City of Portland, Maine - Building or Use Permit Application
 389 Congress Street, 04101 Tel: (207) 874-8703, Fax: (207) 874-8716

Permit No: 05-1835	Issue Date:	CBL: 112 B015001
------------------------------	--------------------	----------------------------

Past Use: Commercial/ Dance Hall	Proposed Use: Change of Use/ Adult day habilitation services	Permit Fee: \$105.00	Cost of Work: \$105.00	CEO District: 1
Proposed Project Description: Change of Use/ Adult day habilitation services		FIRE DEPT: <input type="checkbox"/> Approved <input type="checkbox"/> Denied	INSPECTION: Use Group: Type	
		Signature:	Signature:	
PEDESTRIAN ACTIVITIES DISTRICT (P.A.D.)				
Action <input type="checkbox"/> Approved <input type="checkbox"/> Approved w/Condition <input type="checkbox"/> Denied				
Signature: Date:

Parking Spaces Needed: 22
Parking Spaces Shown: 28

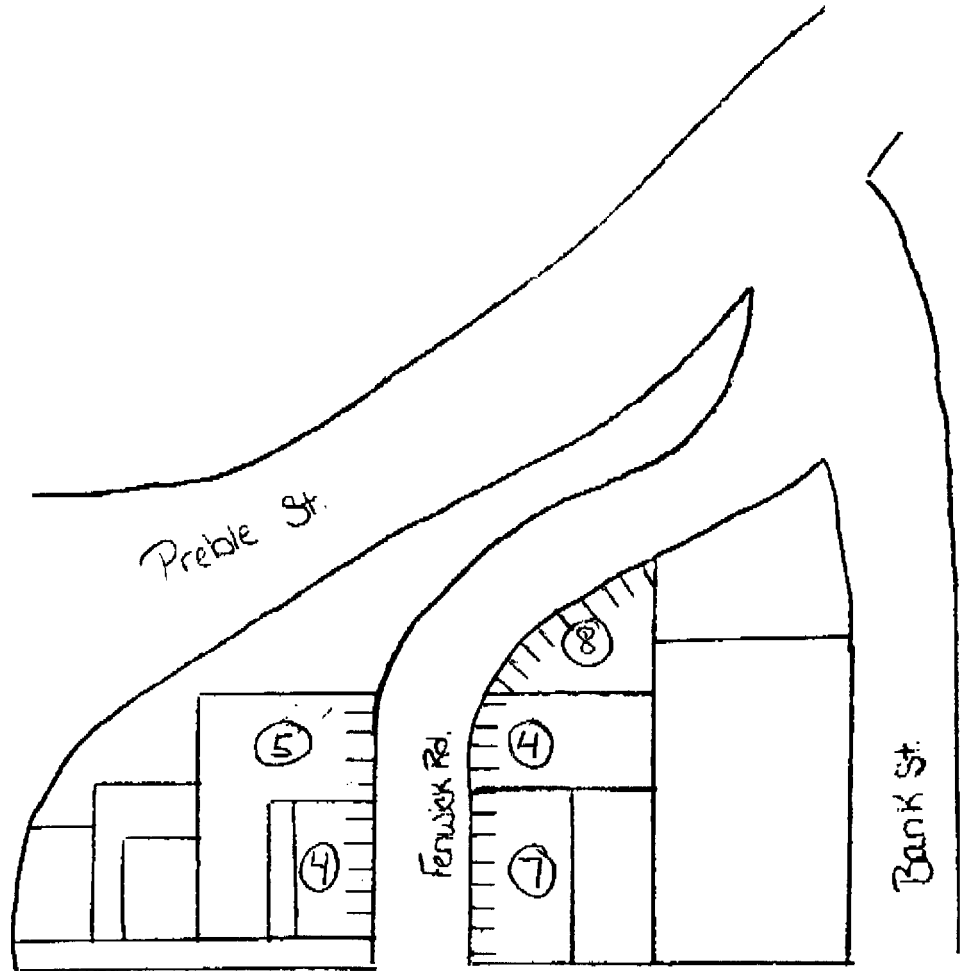
12/29/2005-amachado: Left message with Arthur. He needs to show off street parking. His site plan makes it look like it is on the street. If he uses spaces that are off property he needs permission from the owner. He also needs a letter of permission from D&J Weeks to do the change of use or acopy of their lease.

1/3/2006-amachado: Erin Libby from Support Solutions brought in a letter from the owner saying that Support Solutions can do the change of use and giving them permission to park on their property adjacent to Support Solutions. I told Erin that we still need a site plan that shows off street parking and permission from Palmer Springs if they are parking on their property.
